City of Portland, Maine - Building or Use Permit Application

Permit No: 03-0702	Issue Date: JUN 18 2003	CBL: 087 K001001
-----------------------	----------------------------	---------------------

Proposed Project Description:
Build 16x 20 studio shed w/4x20 porch

ROOF FRAMING

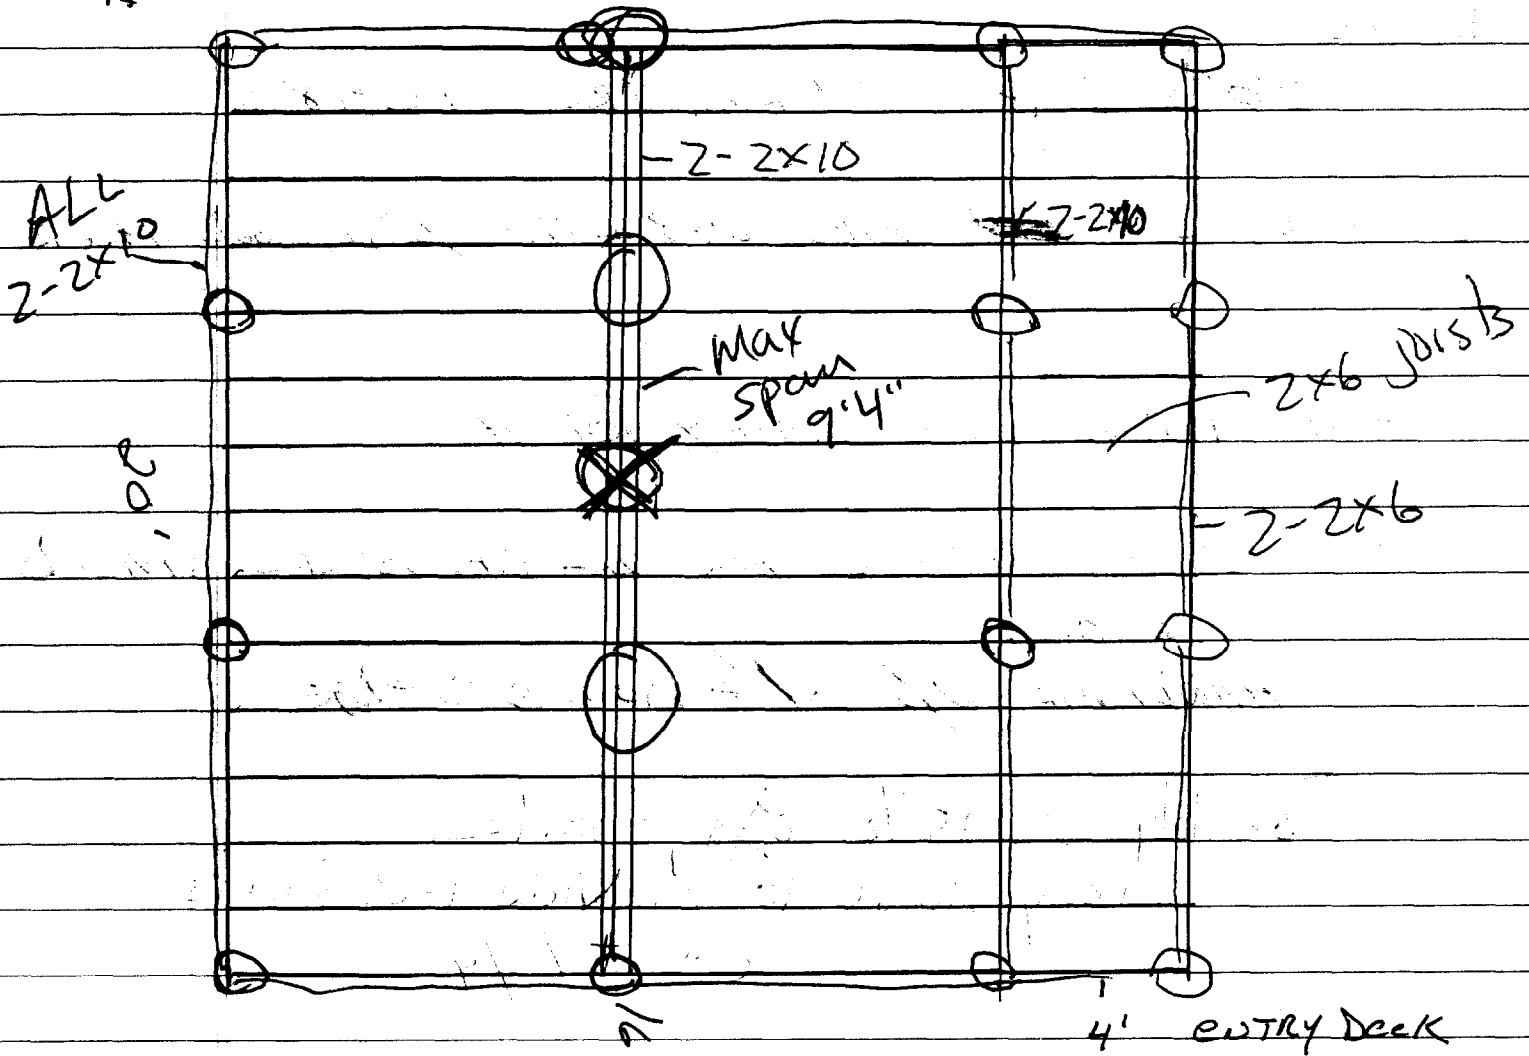
Dept: Building Note:	Status: Approved	Reviewer: Jeanine Bourke	Approval Date: 06/18/2003	Ok to Issue: <input checked="" type="checkbox"/>
1) Design load specs for the engineered ridge shall be submitted to this office
